Subject: FW: Planning Consultation on: AL/20/21/PL

Engineers Comments Regarding Surface Water Drainage

Site Address: Land At Wings Nursery Lidsey Road Woodgate PO20 3SU

Description of Works: Demolition of Wings House & erection of 71 No. replacement dwellings (70 net new dwellings), access arrangements, sustainable drainage measures, public open space, landscaping & all other associated works (resubmission following AL/46/20/PL). This application is a Departure from the Development Plan.

DRAINAGE STRATEGY

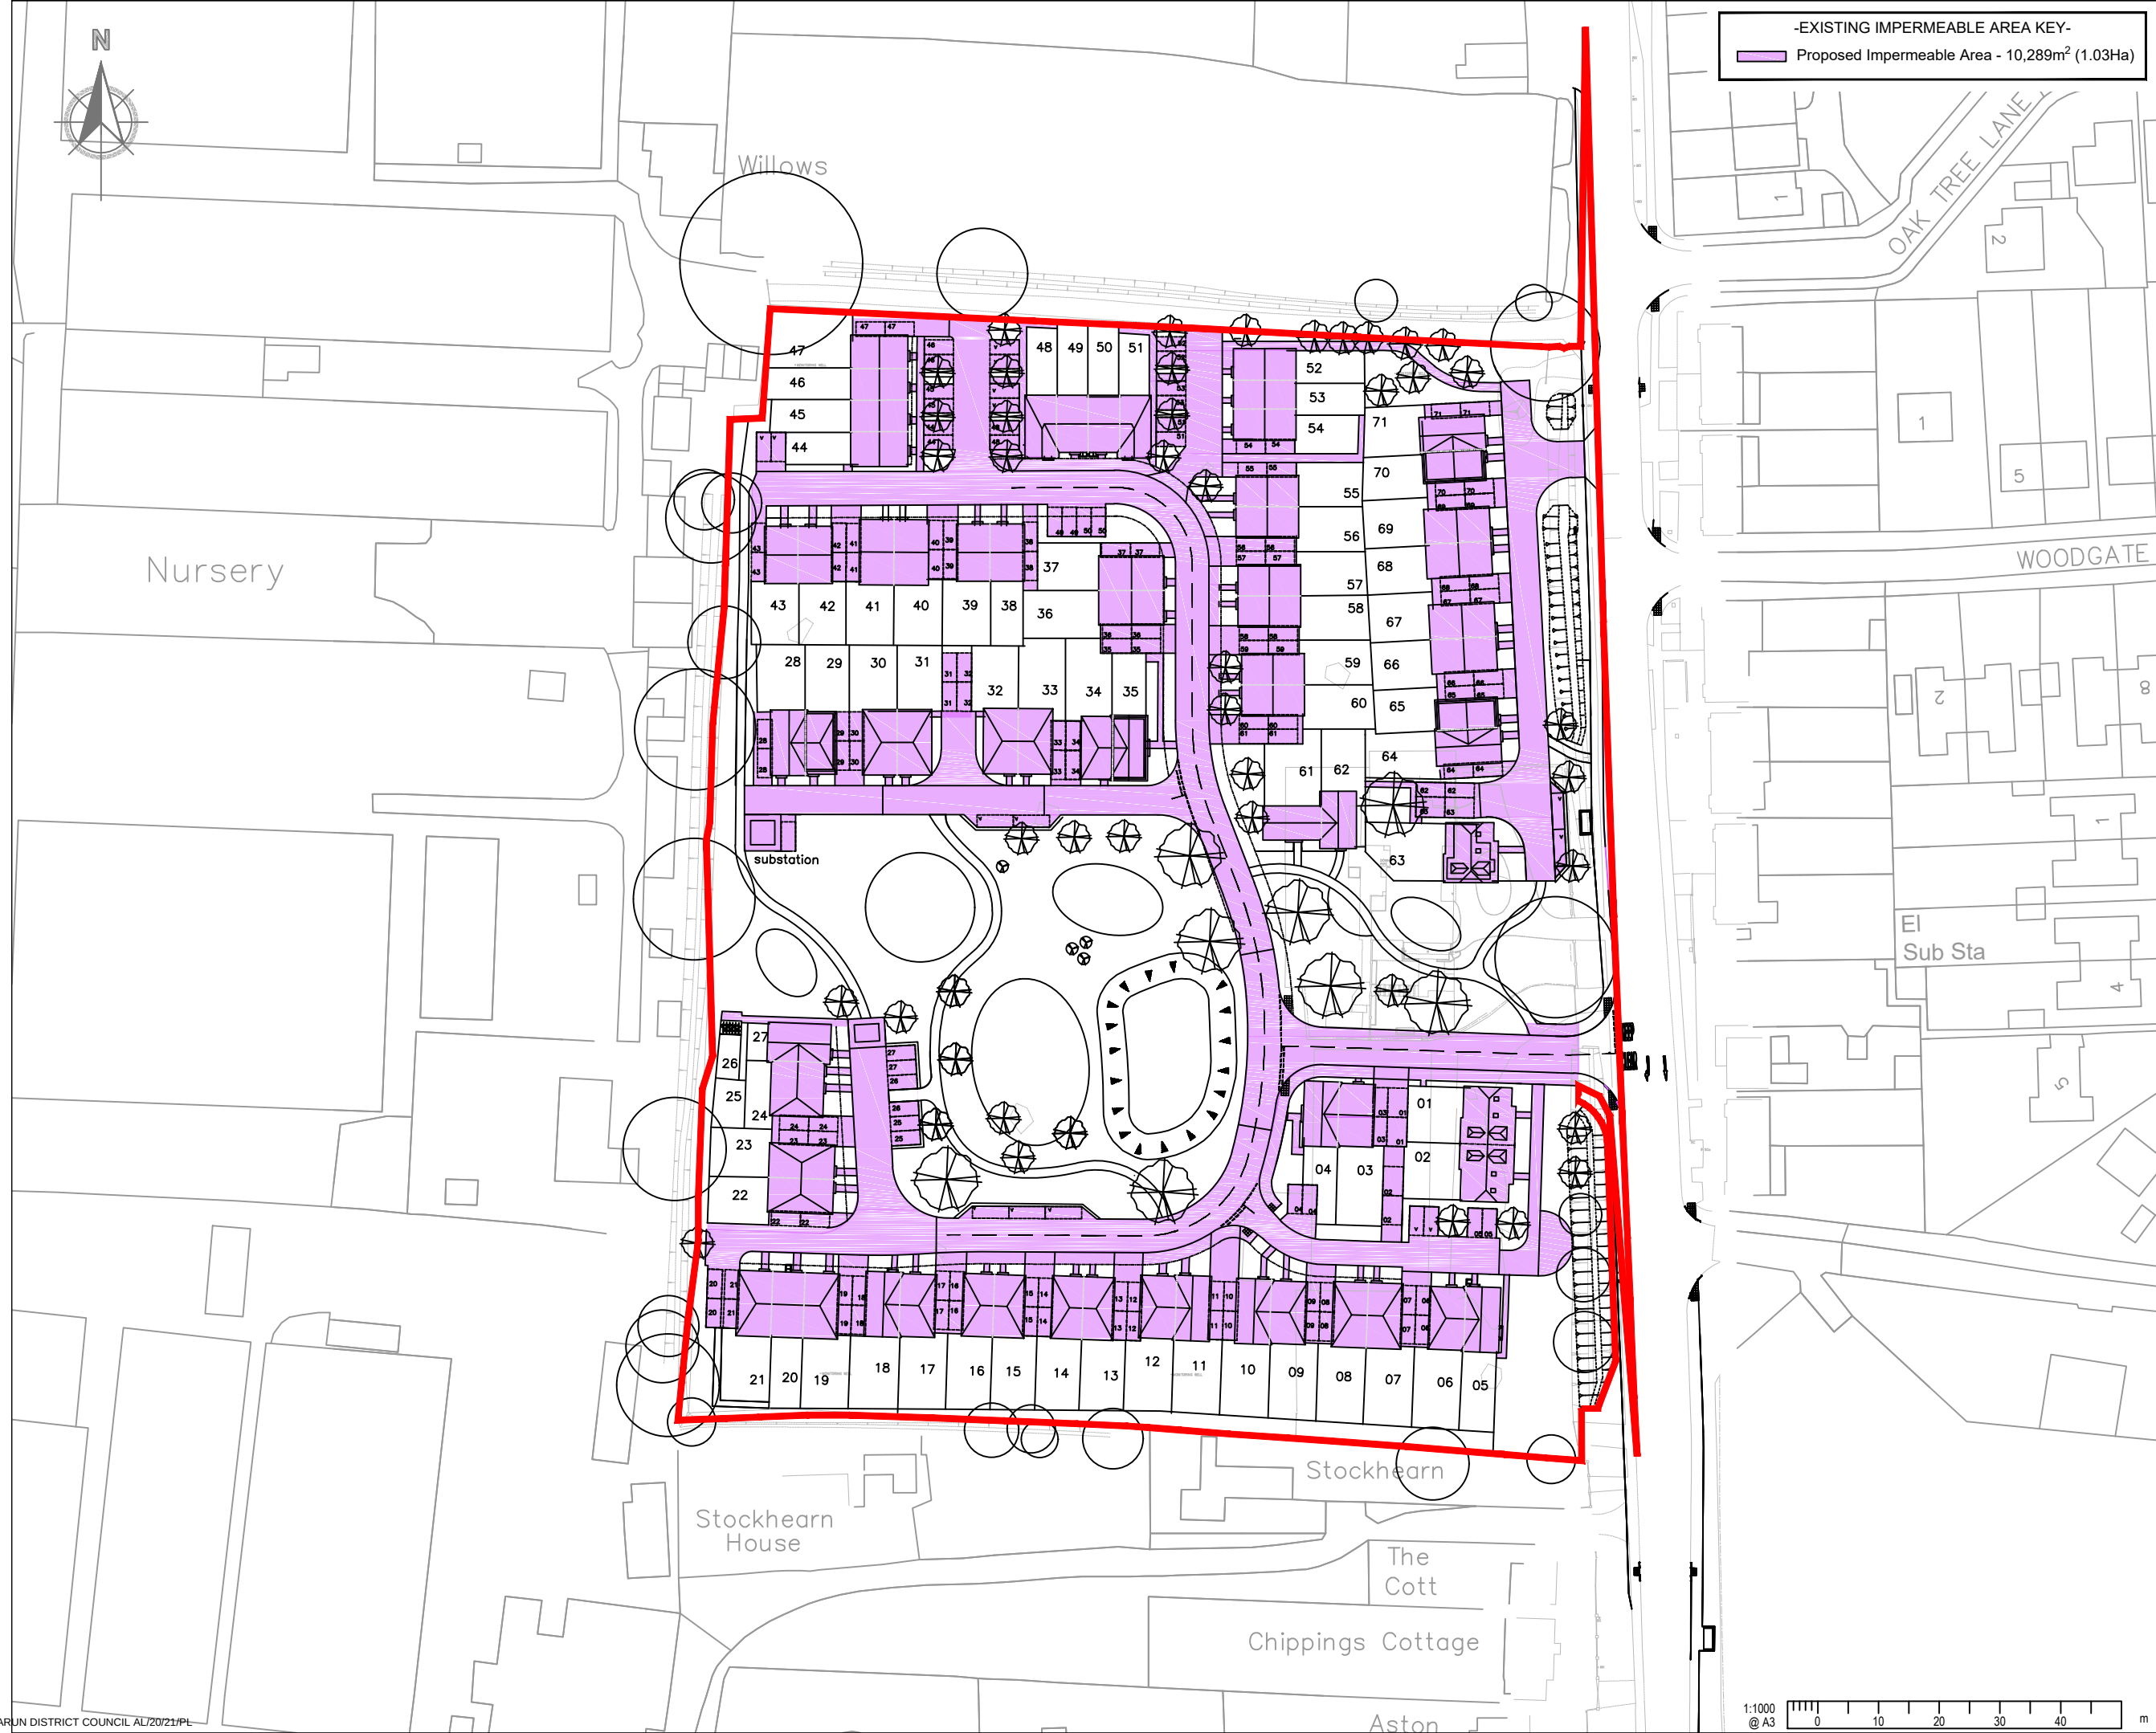
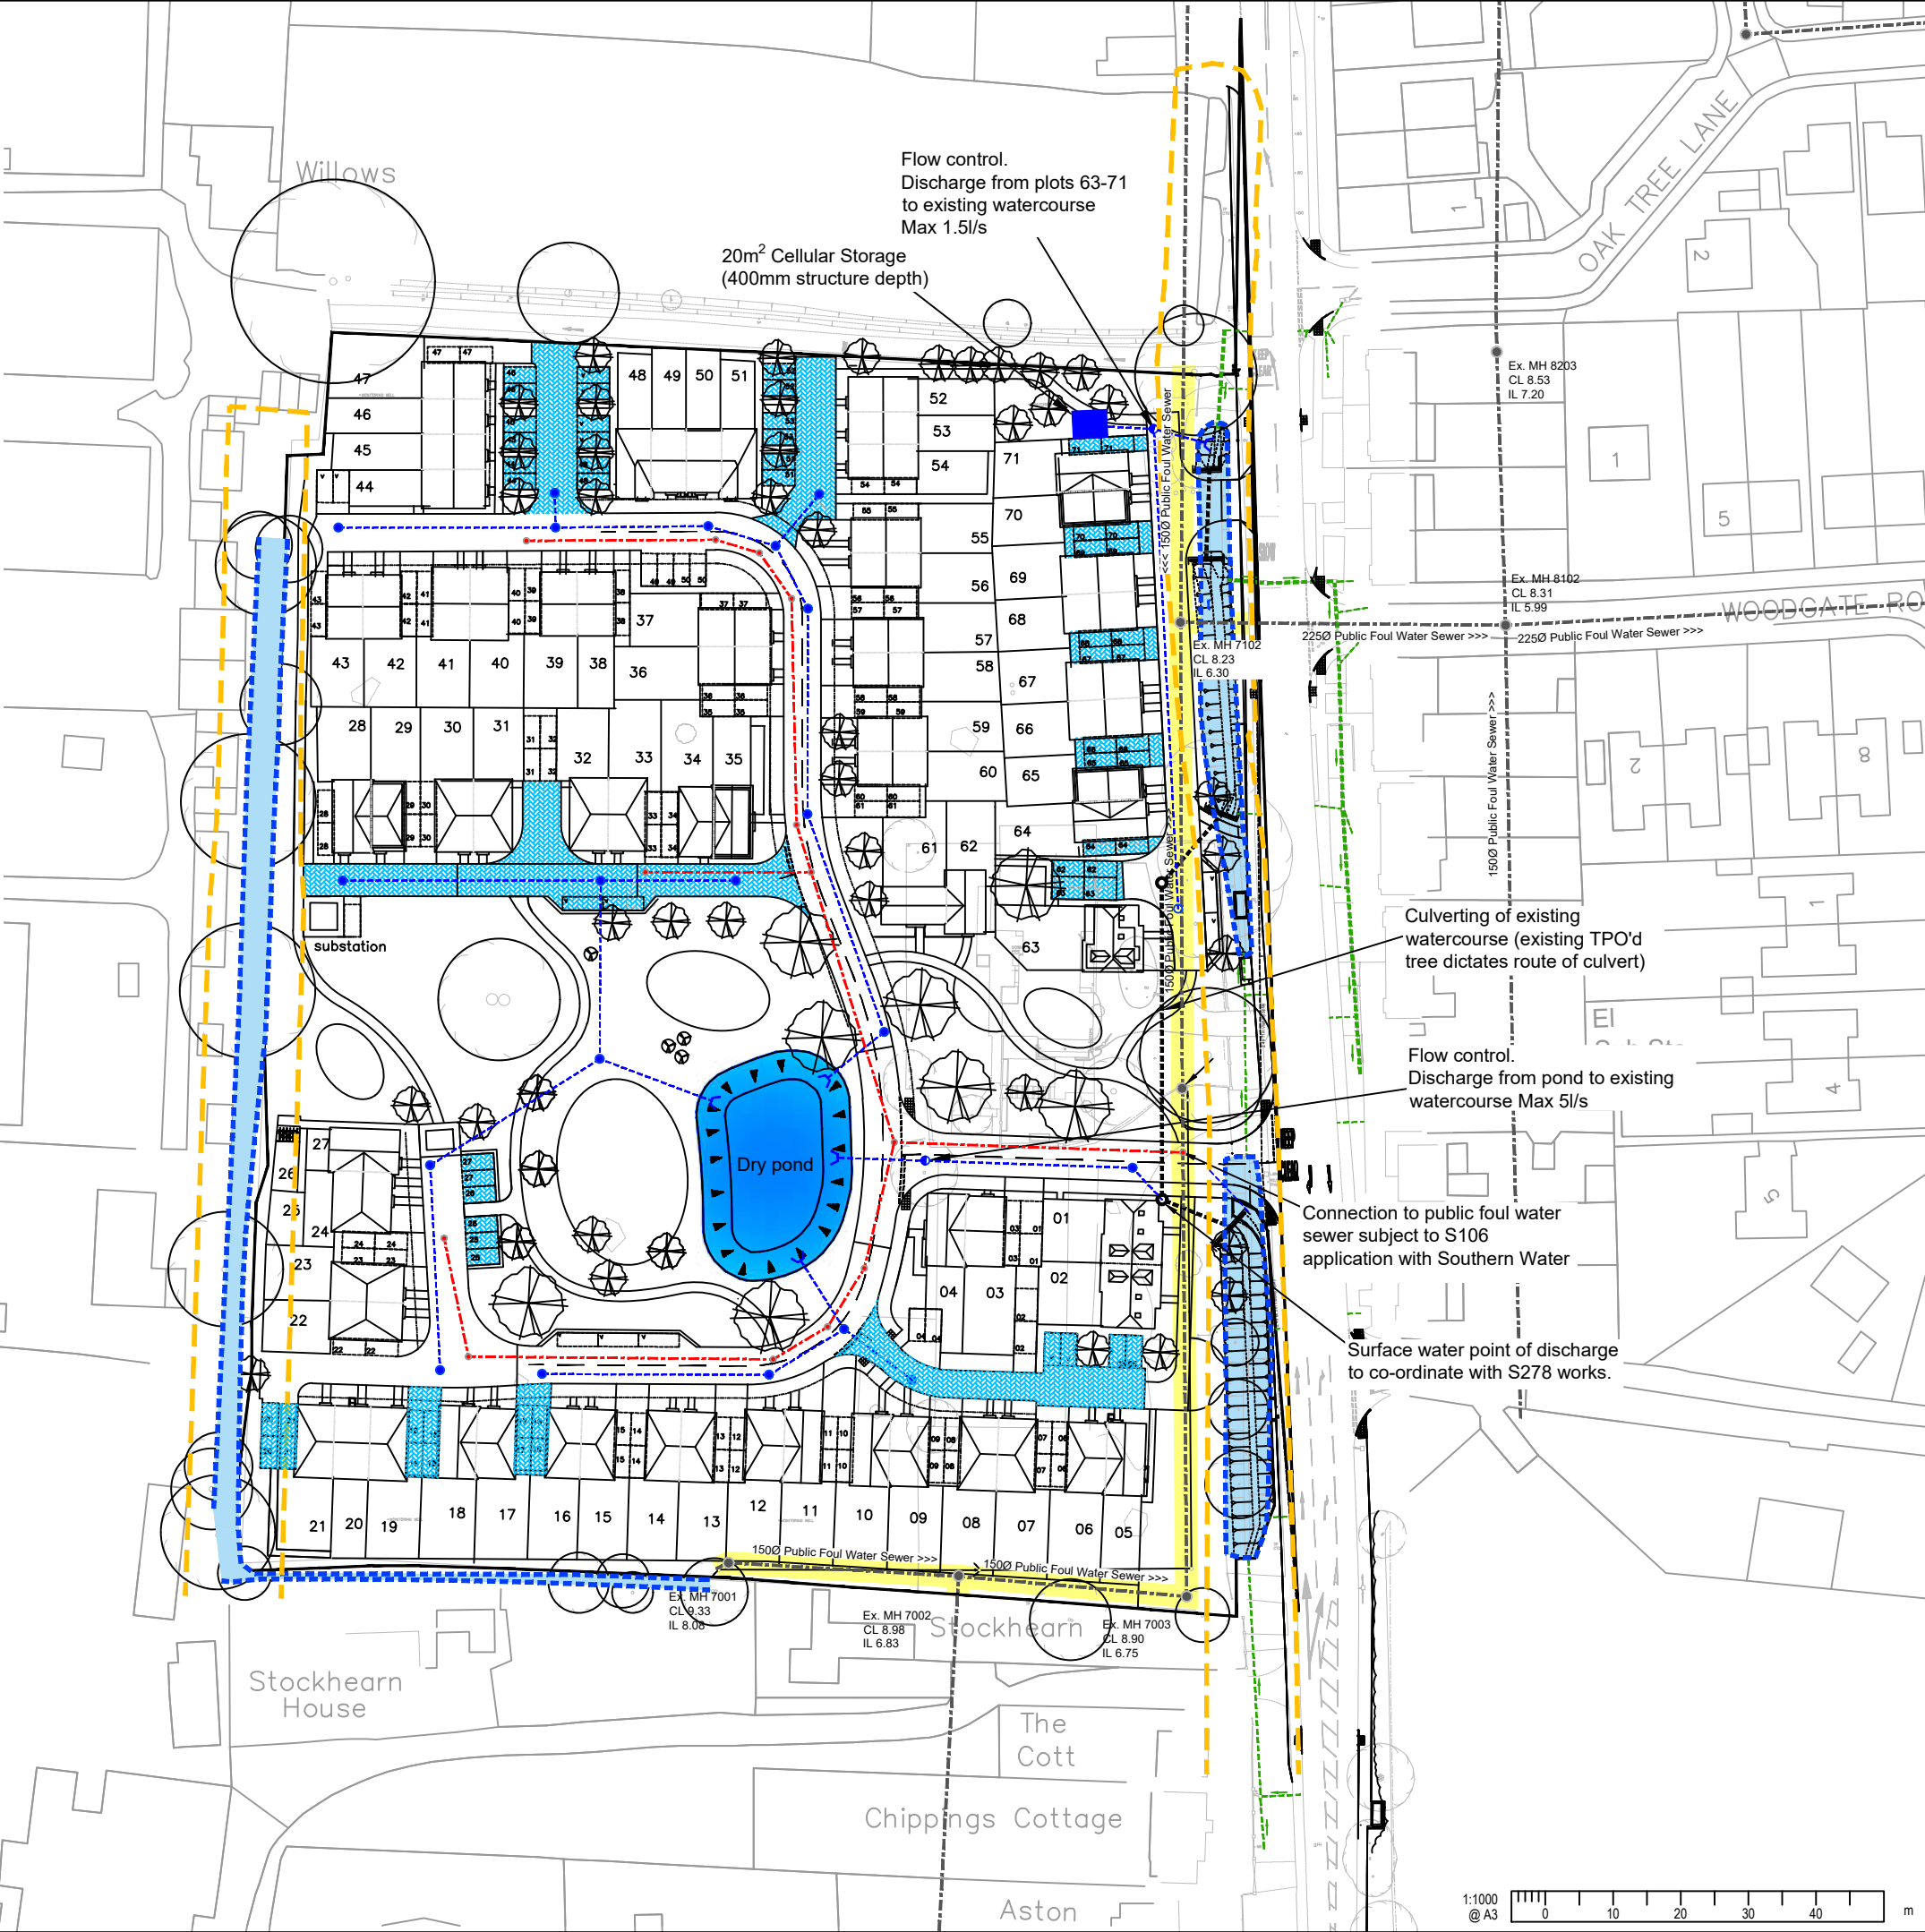
surface water drainage strategy proposes the use of attenuated discharge to the eastern watercourse. This appears to be appropriate.

Given how high groundwater was found on this site we would like to see more details of the preliminary surface water drainage strategy at this time. I.e. more detailed plans that include proposed levels of tanks and basins, preliminary flotation calculations, and proposed levels of points of discharge to watercourses. This is required to demonstrate that a gravity surface water drainage system is implementable within the proposed site layout.

We note that several trees are proposed in close proximity to attenuation features. Please can the applicant supply a plan which shows the attenuation features and tree root potential areas.

The site is bounded to the west, north and east by ordinary watercourses. There is also a small section of ordinary watercourse to the south of the site. The proposed site layout appears to show additional crossings over the watercourse to the east of the site, land drainage consent will be required for this, the number of crossings should be kept as low as possible. We also note that there are visitor bays proposed very close to this eastern watercourse, and that numerous properties have fence lines in close proximity to the other ordinary watercourses. Improvements will be required to the bounding ordinary watercourses.

1. A layout plan which clearly shows at least a 3m buffer from the top of bank of watercourses to any fences, buildings, or structures.
2. Further details of the surface water drainage strategy. Including; more detailed plans that include proposed levels of tanks and basins, preliminary flotation calculations, and proposed levels of points of discharge to watercourses
3. A plan which shows the attenuation features and tree root potential areas.
4. Further details of proposed land raising.
